**Consultation Response from KC,
Ecology Unit**

2026/91763 Land off Barnsley Road, Denby Dale, Huddersfield

Erection of 40 residential dwellings and associated works

Date Responded: 05/08/2026

SITE LAYOUT PLAN - 2530-SI-02F
BARNSLEY ROAD, DENBY DALE
NEWETT HOMES
SCALE:1:500@A1 - AUGUST 2025

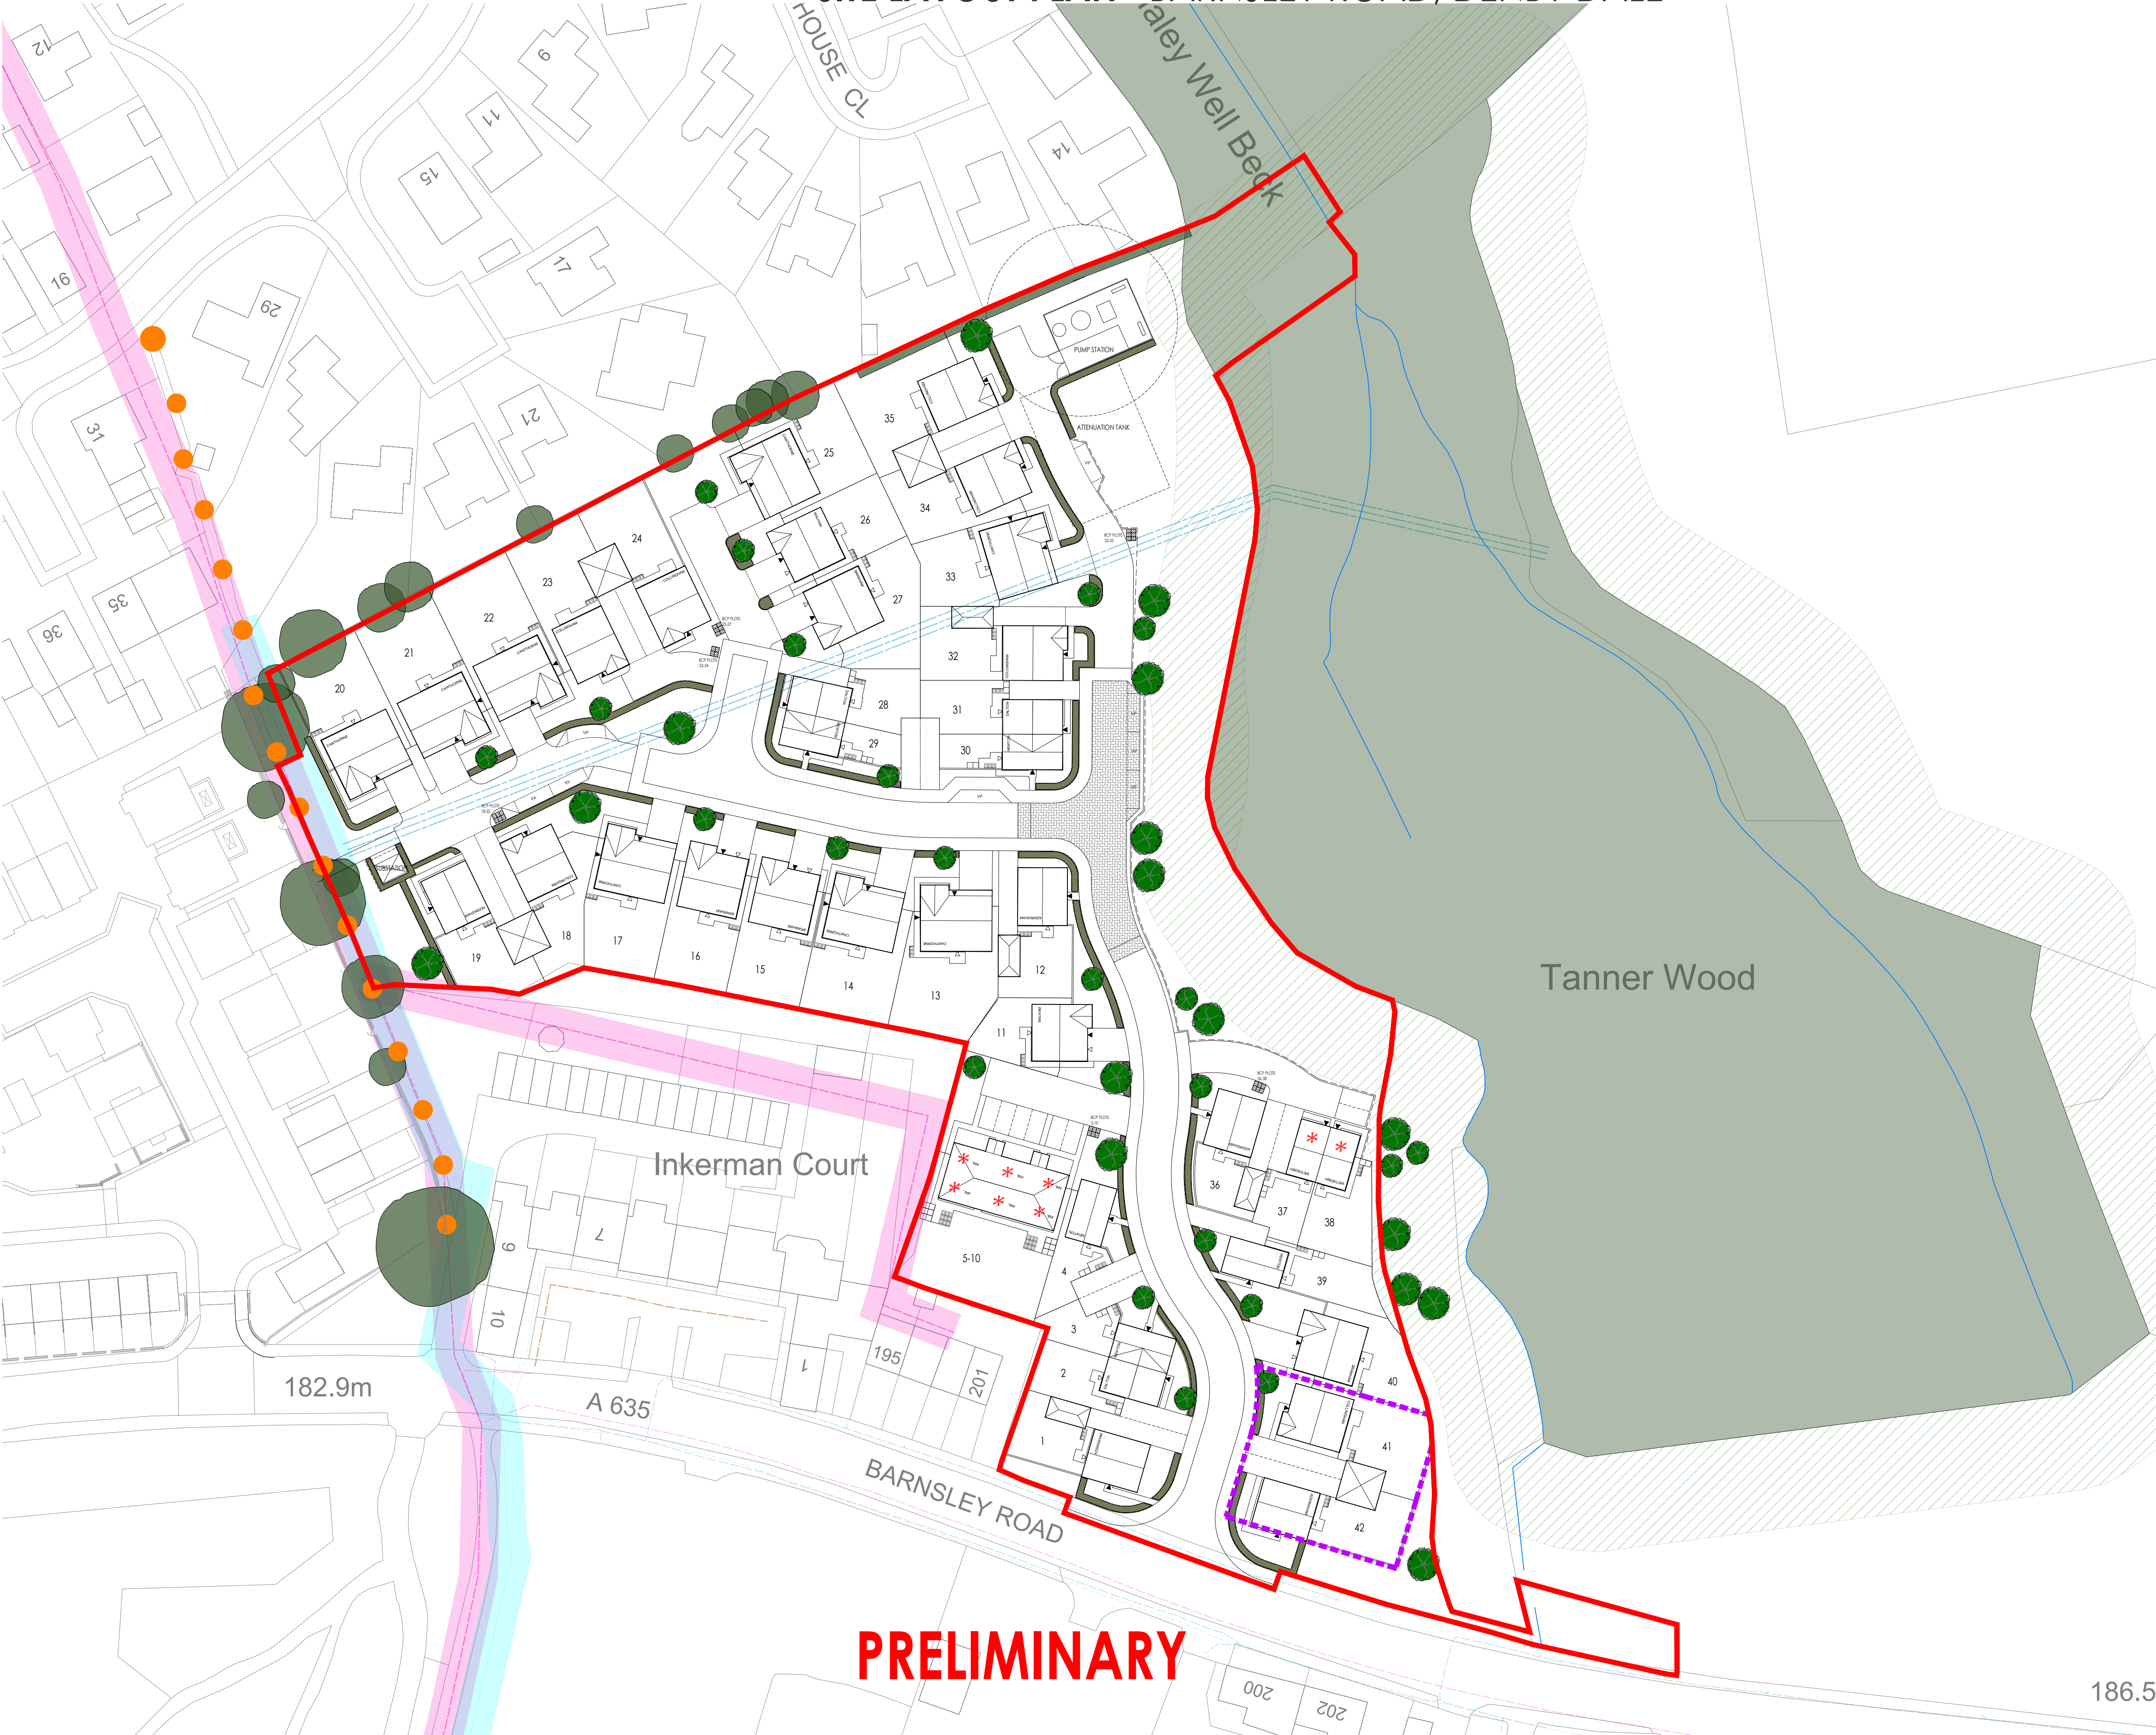
I would also recommend that the Ecological Impact Assessment is updated to detail what the impacts on the ancient woodland will be. The Proposed Site Plan shows an offshoot from the development through the Ancient Woodland to the Beck. Is this to do with the drainage of the site? No details what the impacts of this on the Ancient Woodland have been provided within the ecological reports. I would recommend that the Ecological Impact Assessment is updated to

provide further detail on this. Ancient Woodland is an irreplaceable habitat, and activities which negatively impact on the woodland should not be permitted.

From the Site Layout Plan, it also appears that the gardens for dwellings 1-6 are within the buffer zone for the Ancient Woodland. This is inappropriate. 15m is the minimum buffer for root protection purposes. Homeowners are permitted to undertake works in their garden which could negatively impact on the trees and ancient woodland, such as installing an impermeable surface, or digging and damaging the tree roots. The scheme should be amended to ensure that the buffer around the ancient woodland is free from all development. I would also recommend that this buffer is extended to a more appropriate distance. [Research has shown](#) that 95% of human encroachment activity was found within 34m of a woodland edge, and where gardens backed onto woodland, residents were likely to install gates to permit themselves access to the woods. Measures such as a 30 or 35m planted buffer, are likely to reduce this encroachment.
